OBJECTION TO PLANNING APPLICATION

Application reference: 2026/62/92200/E

Site: Scholes Cricket and Athletic Club, New Popplewell Lane, Scholes, Cleckheaton, BD19 6NN

Proposal: Formation of two outdoor padel courts and associated works

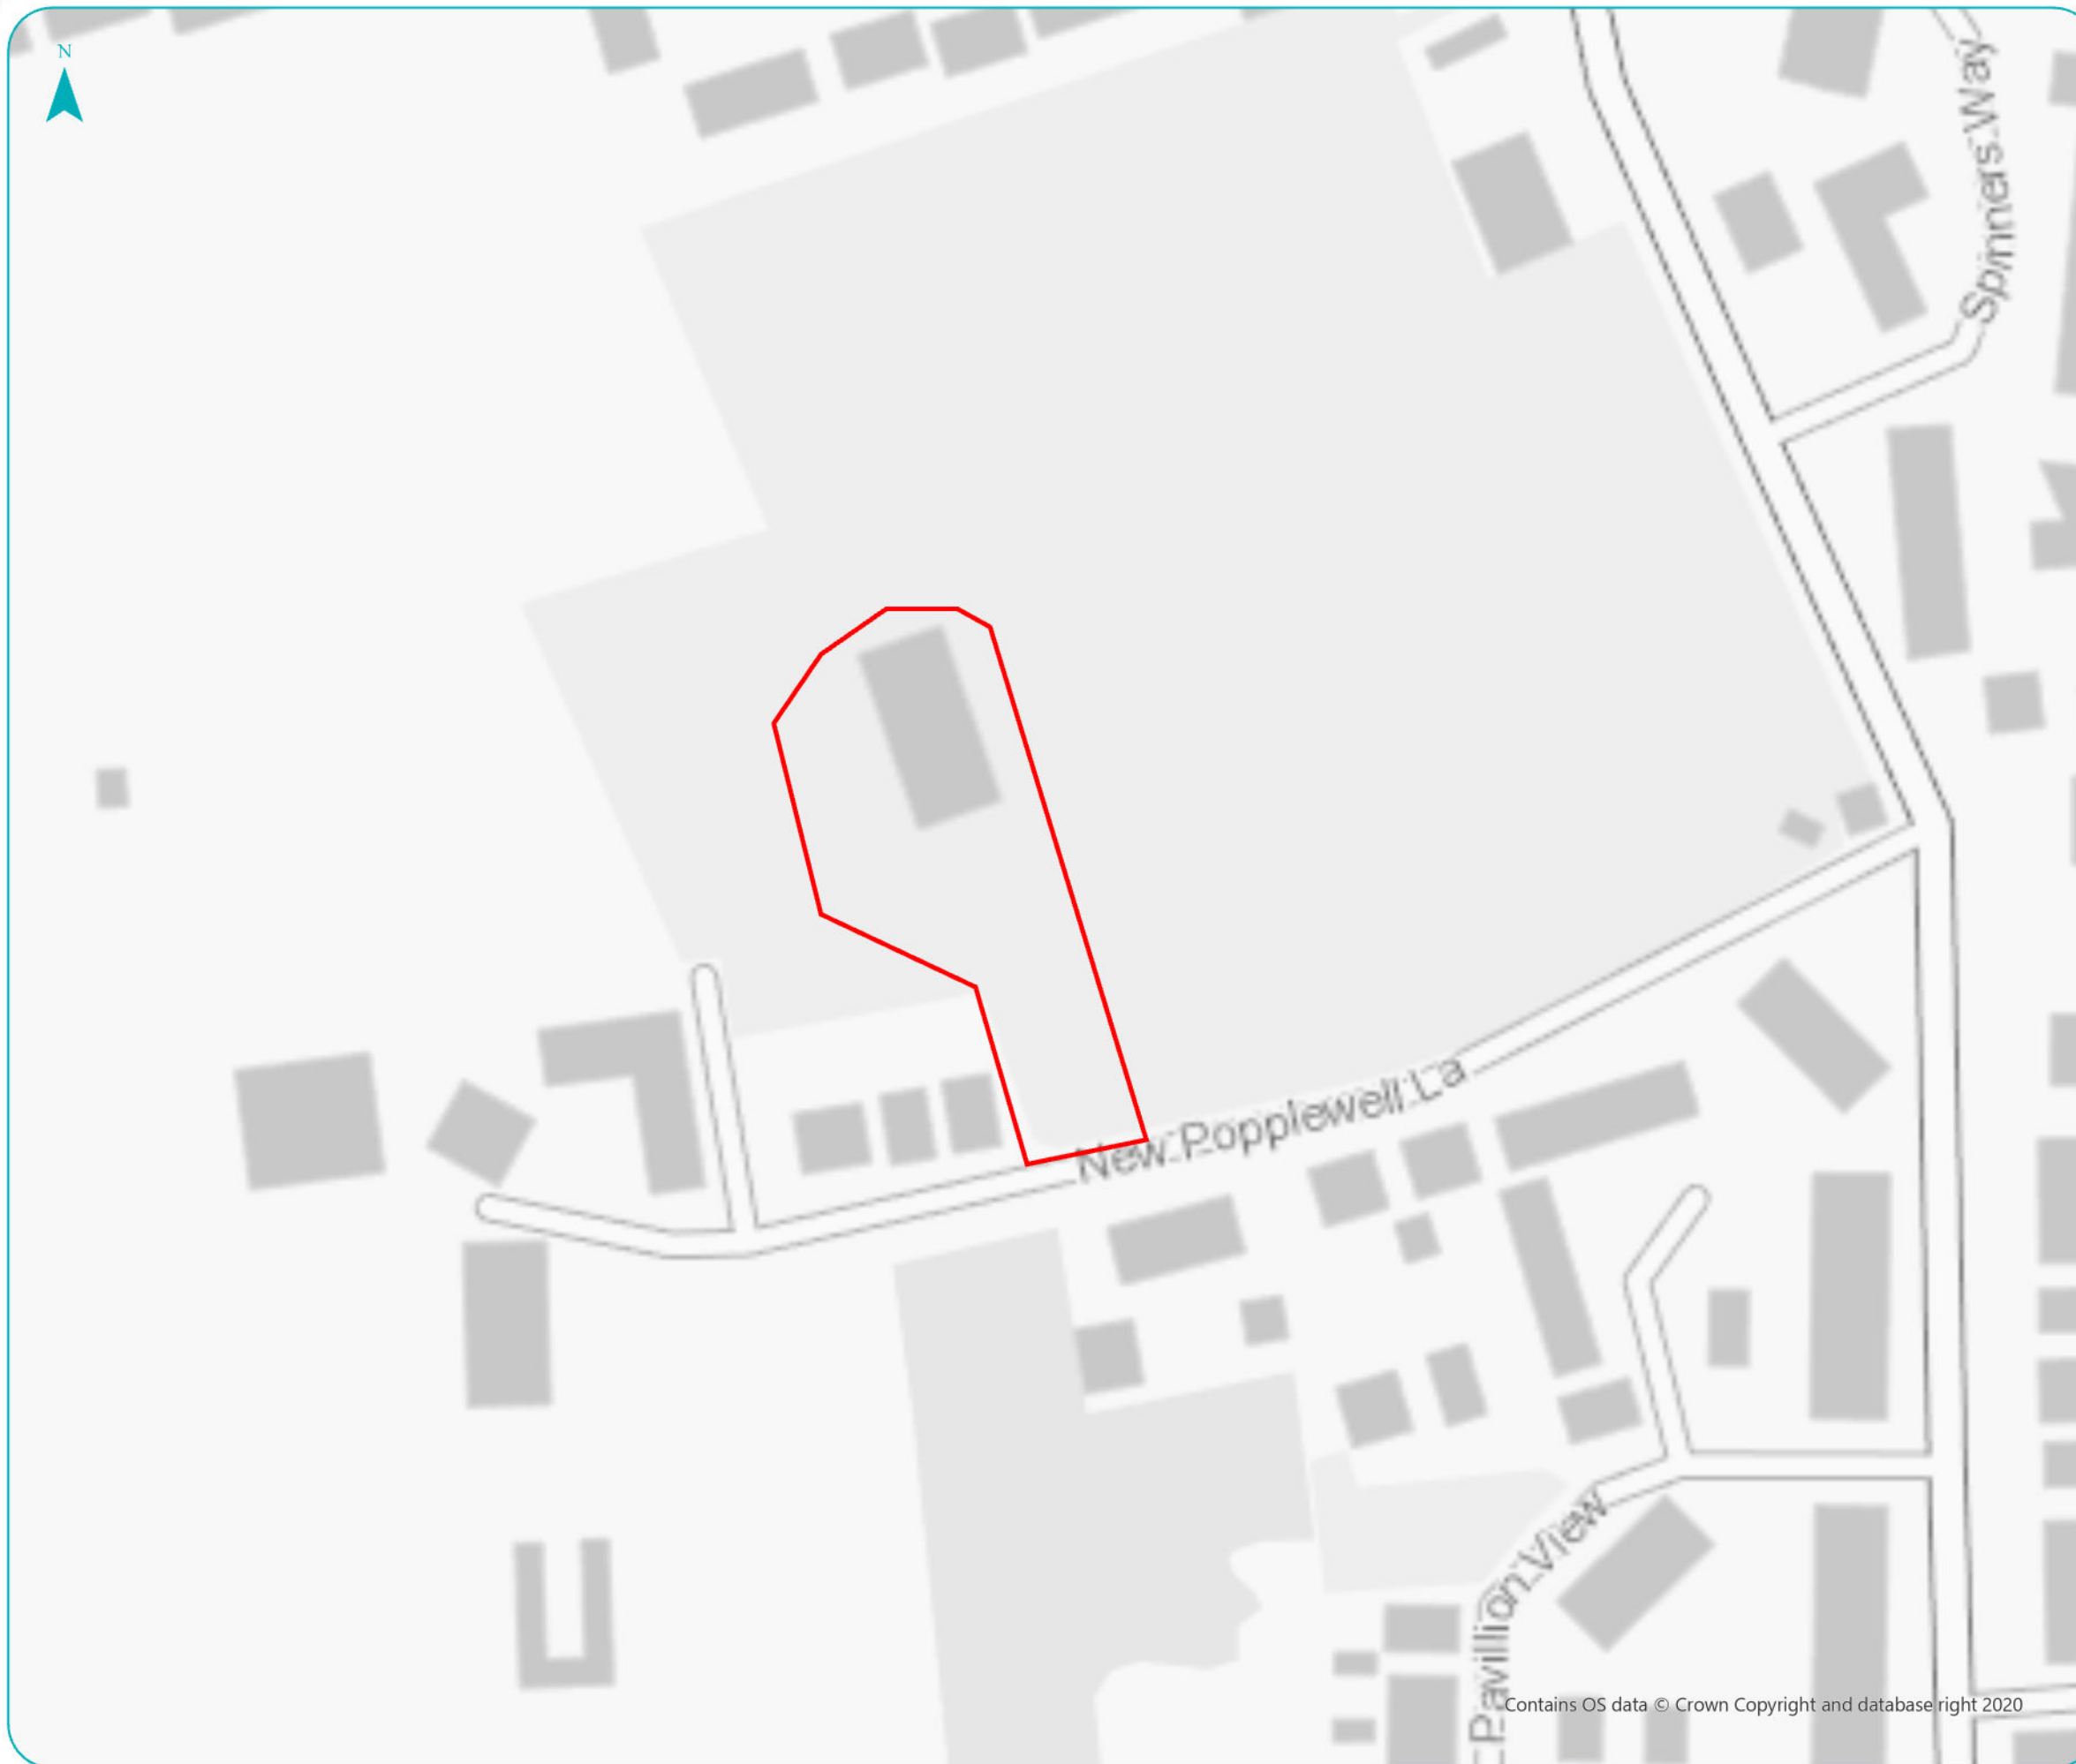
The Transport Statement states that 8 of the 29 spaces will be reserved for padel, *"leaving 21 for the remaining uses of the Site."* That figure is wrong, because it counts restricted bays as if they were generally available. Reading the Car Parking Layout drawing:

- 5 bays are **accessible bays** (12, 13, 14, 28, 29)
- 4 bays are marked **"ELECTRIC VEHICLE CHARGING ONLY"** (24, 25, 26, 27)
- 8 bays are **reserved for padel**

That leaves **12 unrestricted spaces** for cricket, football, staff, spectators, deliveries and clubhouse users — not 21. On the applicant's own peak figure of 54 users on Saturdays and Sundays, overspill onto the surrounding streets is not a risk to be managed; it is the inevitable outcome of the layout.

The Car Parking Layout does not show the existing storage containers, bottle banks or gas bottle enclosure on the site, and makes no evident provision for access to them. The bottle banks have already been acknowledged as a nuisance and relocated once within the site as a result.
